May 4, 2022

**Re: CARMEL APARTMENTS B**  
**7310 Carmel Ave. NE**  
**Traffic Circulation Layout**  
Architect's Stamp 03-03-2022 (C19-D069)

Based upon the information provided in your submittal received 04-13-2022, the above referenced plan cannot be approved for Building Permit until the following comments are addressed:

**TRAFFIC CIRCULATION
LAYOUT APPROVED**

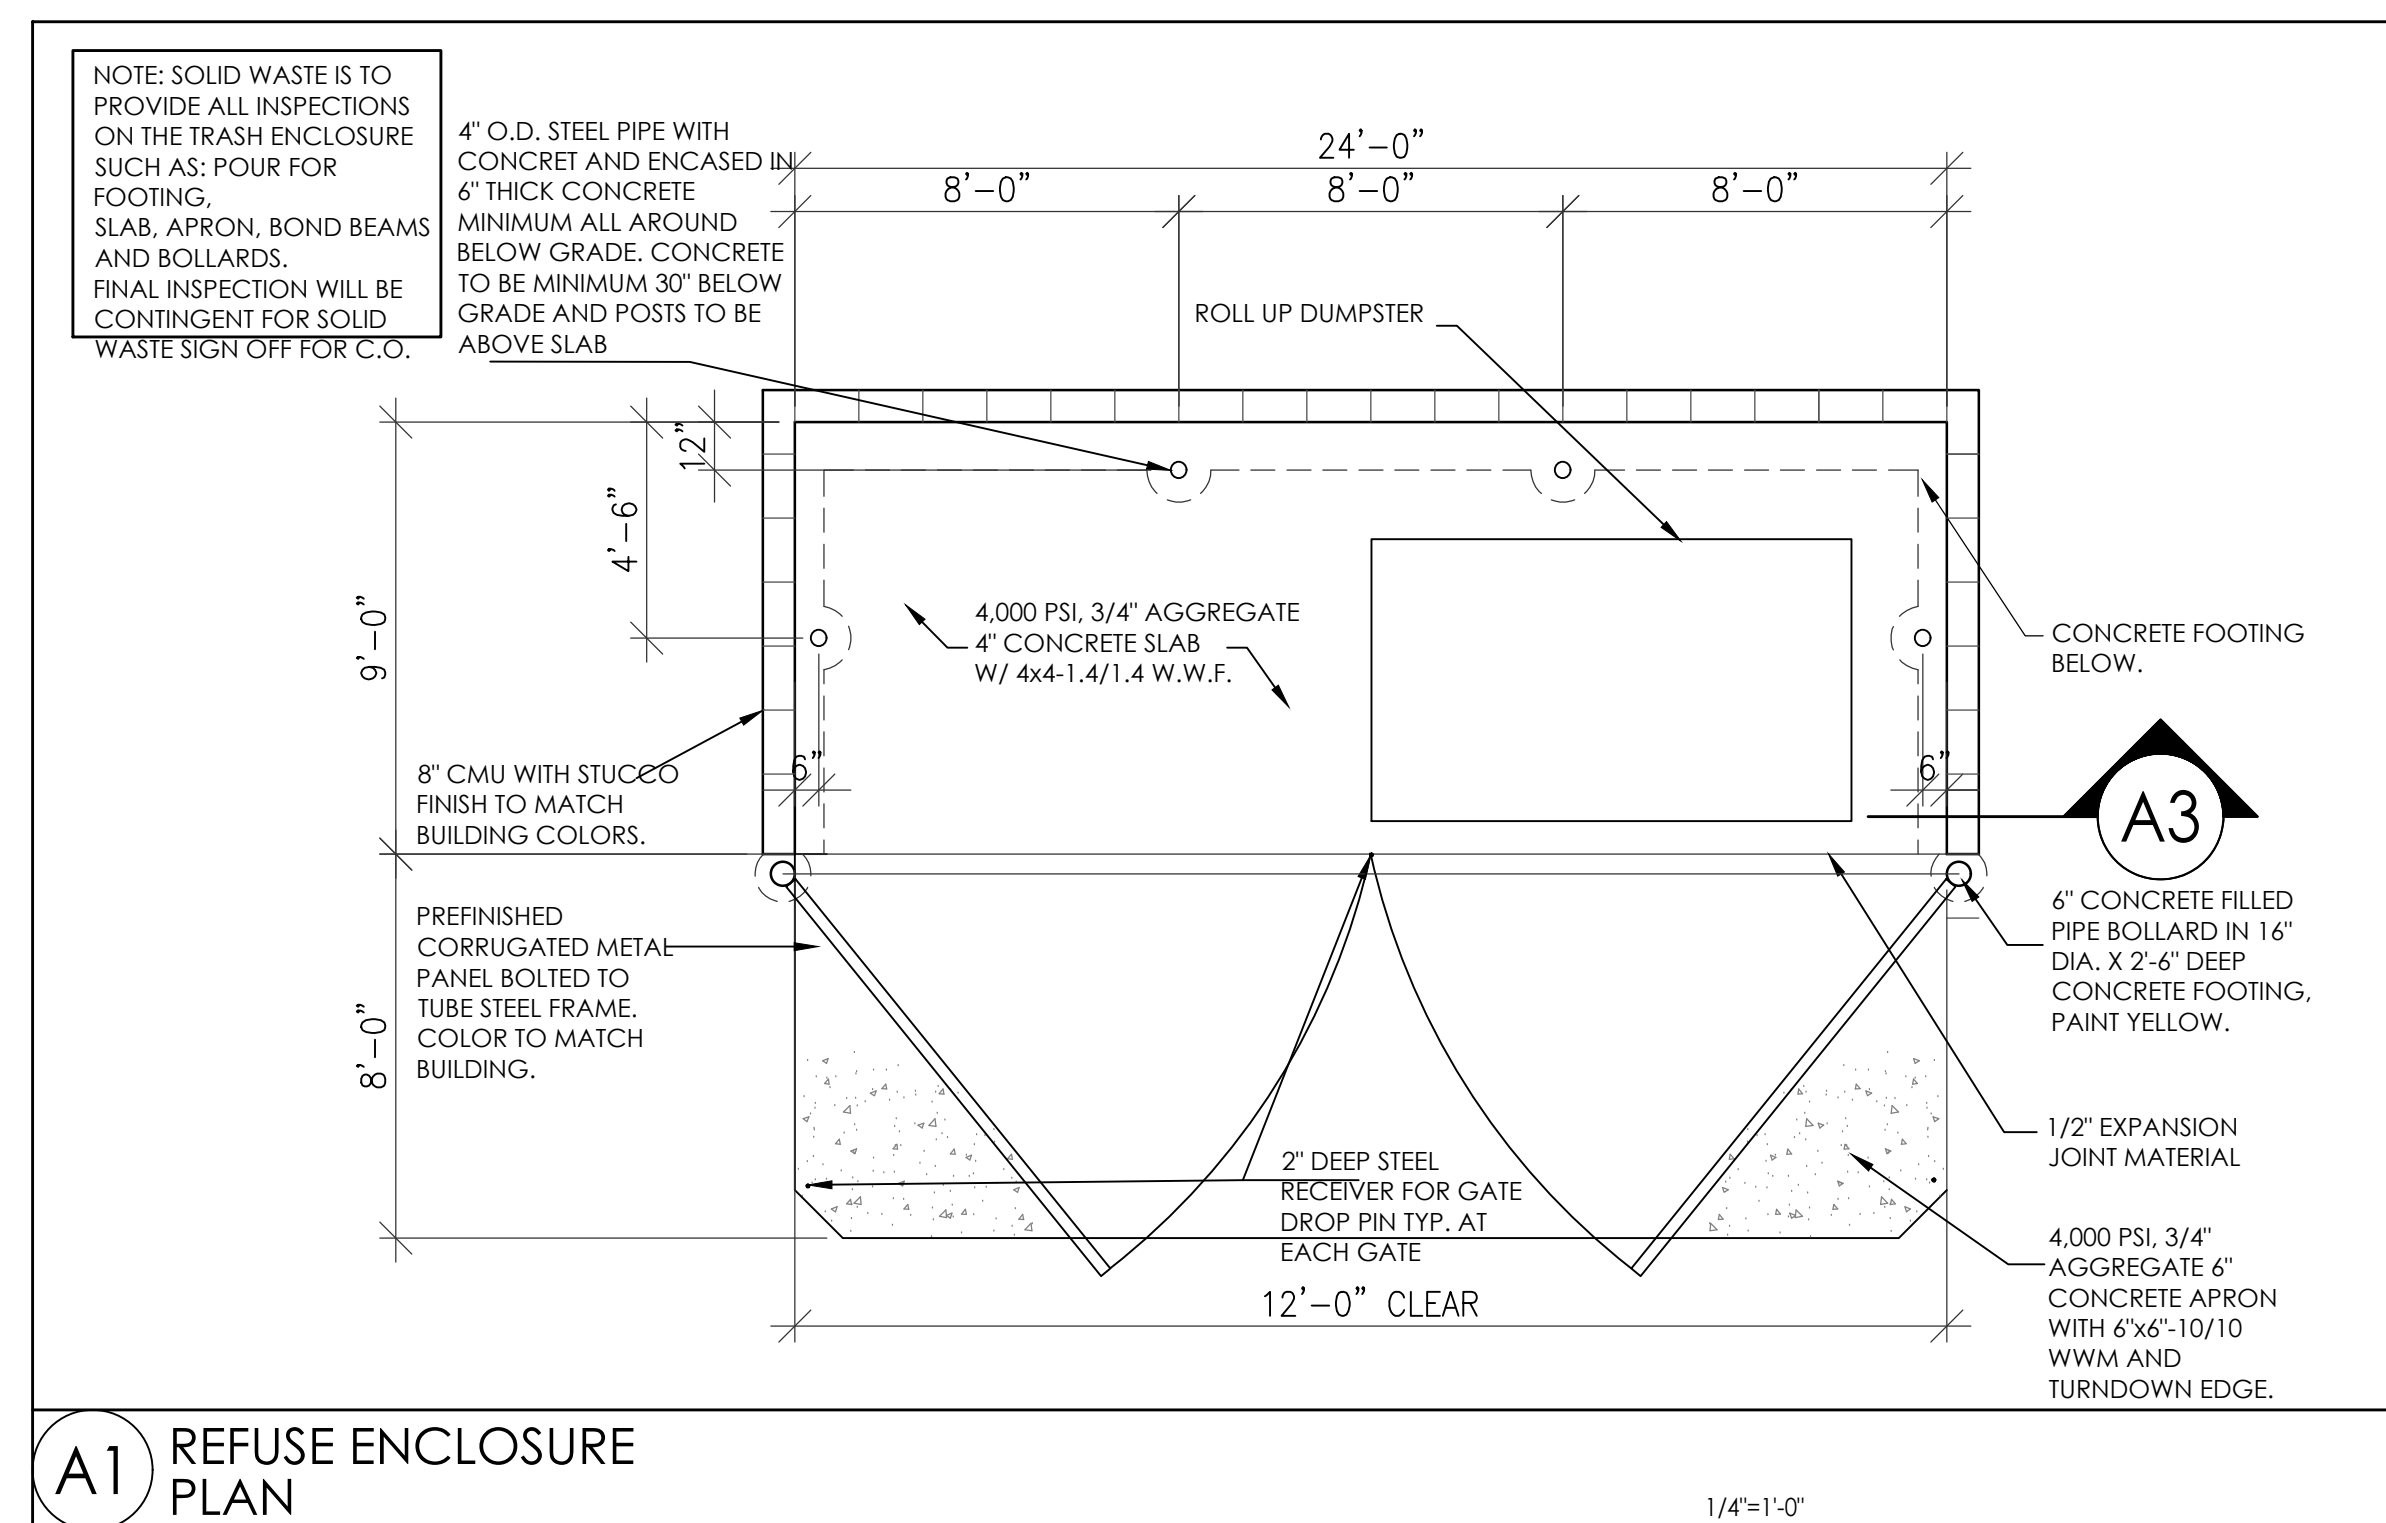
7. **Detail A4:** Paint Bollards yellow.
  8. **Detail A8:** Note 50:1 max on top of sidewalk and 12:1 max for taper. Stall widths are 8'-6" not 8'-0"-6" please adjust text.

AS-1.0

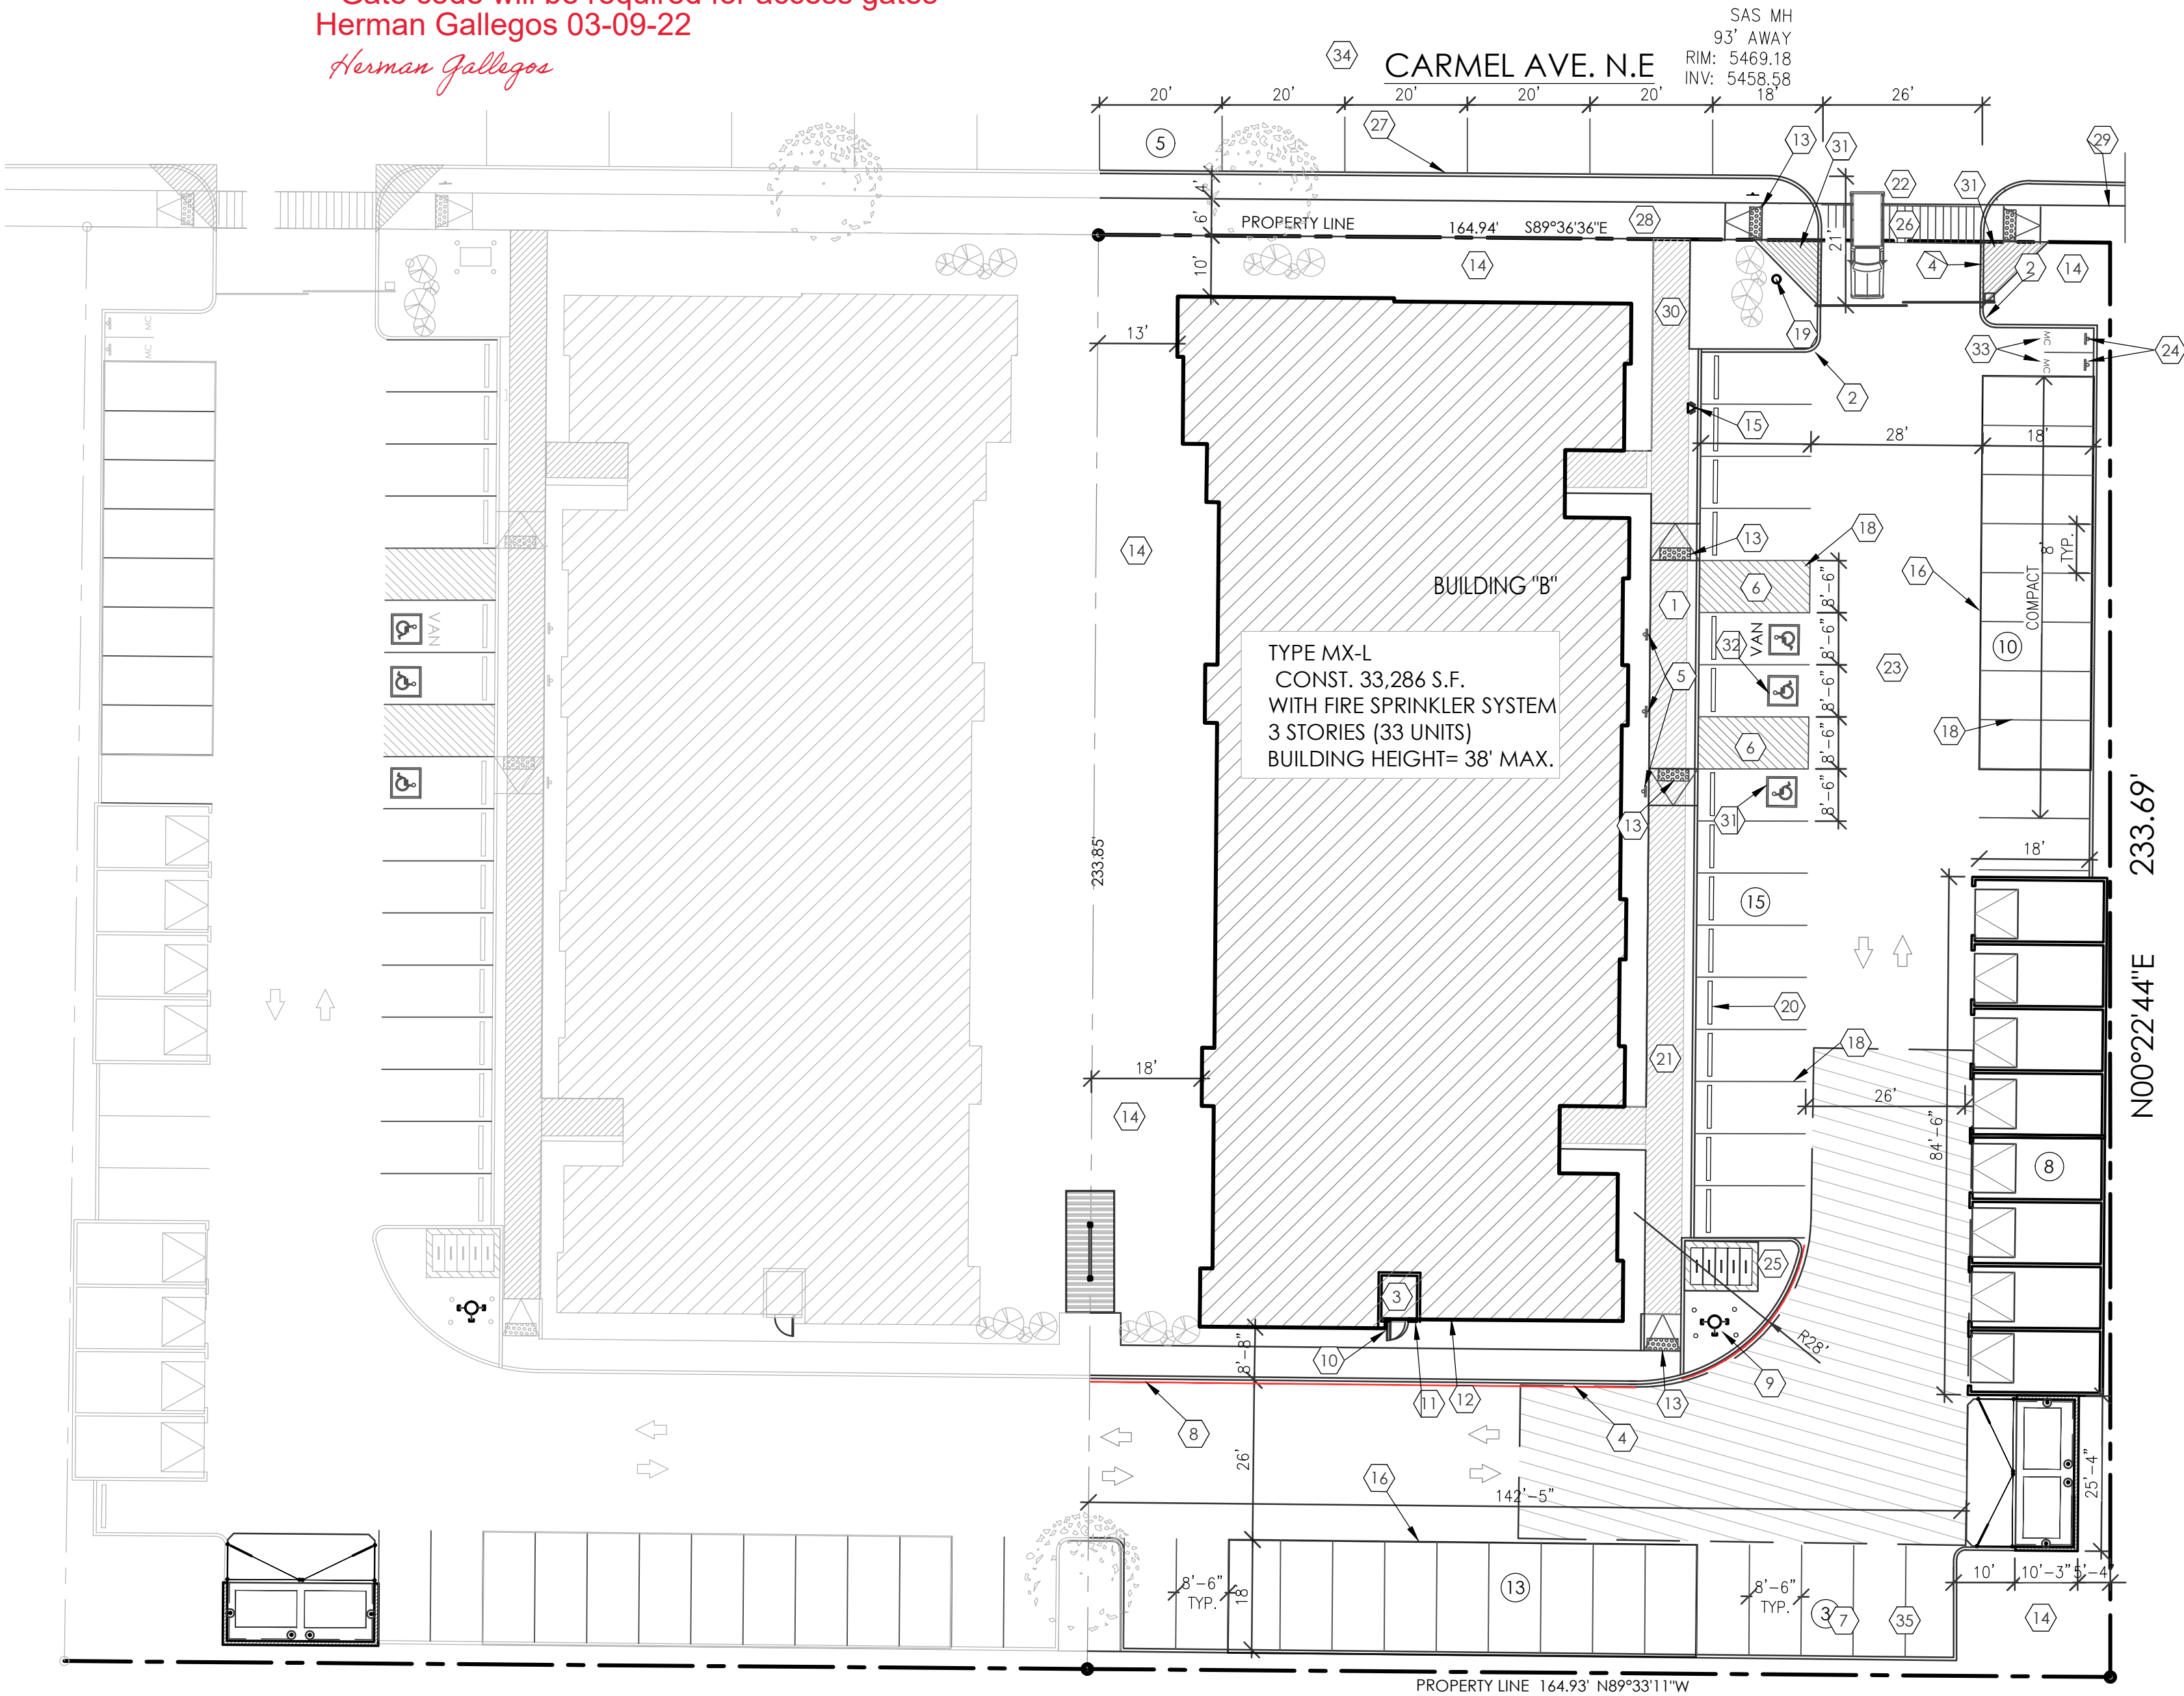
- Provide a 5:1 taper at end of sidewalk on eastern portion if needed.
  - **Keyed Note 22:** Change notation from drivepad to driveway and show the 6 ft valley gutter as part of the entrance drawing.

- **Keyed Note 26:** Proposed cross pathway striping will need detail for striping.

- **Keyed Note 28:** Provide a tie-in grade of 5:1 back to existing surface elevation at end of sidewalk.
  - **Keyed Note 29:** Reference COA std dwg 2430 for sidewalk detail and provide a tie-in grade of 5:1 back to existing surface elevation at end of sidewalk.

- **Keyed Note 34:** Nope, remove this note.
3. An secondary emergency access will need to be provided as part of this proposed development and a temporary paved connection back to Carmel Ave will be needed as part of the TCL requirement.

4. **Keyed Note 1:** Reference A8/AS-2.0 instead of A10.
  5. **Keyed Note 13:** Reference either detail A8 or A10 on sheet AS-2.0 for proposed ramp.
  6. **Keyed Note 21 & 30:** Reference A5/AS-2.0.

9. **Detail A10:** 50:1 and 12:1 should have the word max. after each text.
  10. **ADA Parking Access Aisle dimensions (on site plan):** You specify 8'-6" on layout but on detail you call out 8'-0". Please address this concern.

11. **Proposed Compact parking stalls:** Provide stall lengths for compact parking stalls.
  12. You have a hatch area/segment of pavement around the drive aisle located at the corner back of the proposed building and no legend to define this hatching. Please provide some type of note to define this hatching.

18. Label the compact parking spaces by placing the words "**COMPACT**" on the pavement of each space.
19. The ADA accessible spaces must include an access aisle. Van accessible aisles should be **8ft wide**; all others should be 5ft wide.

20. **Motorcycle parking spaces:** Provide stall widths.
21. Please specify the City Standard Drawing Number when applicable.
22. Shared Site access: driveways that straddle property lines, or are entirely on one property but are to be used by another property, shall have an access easement. Please include a copy of your shared access agreement with the adjacent property owner.
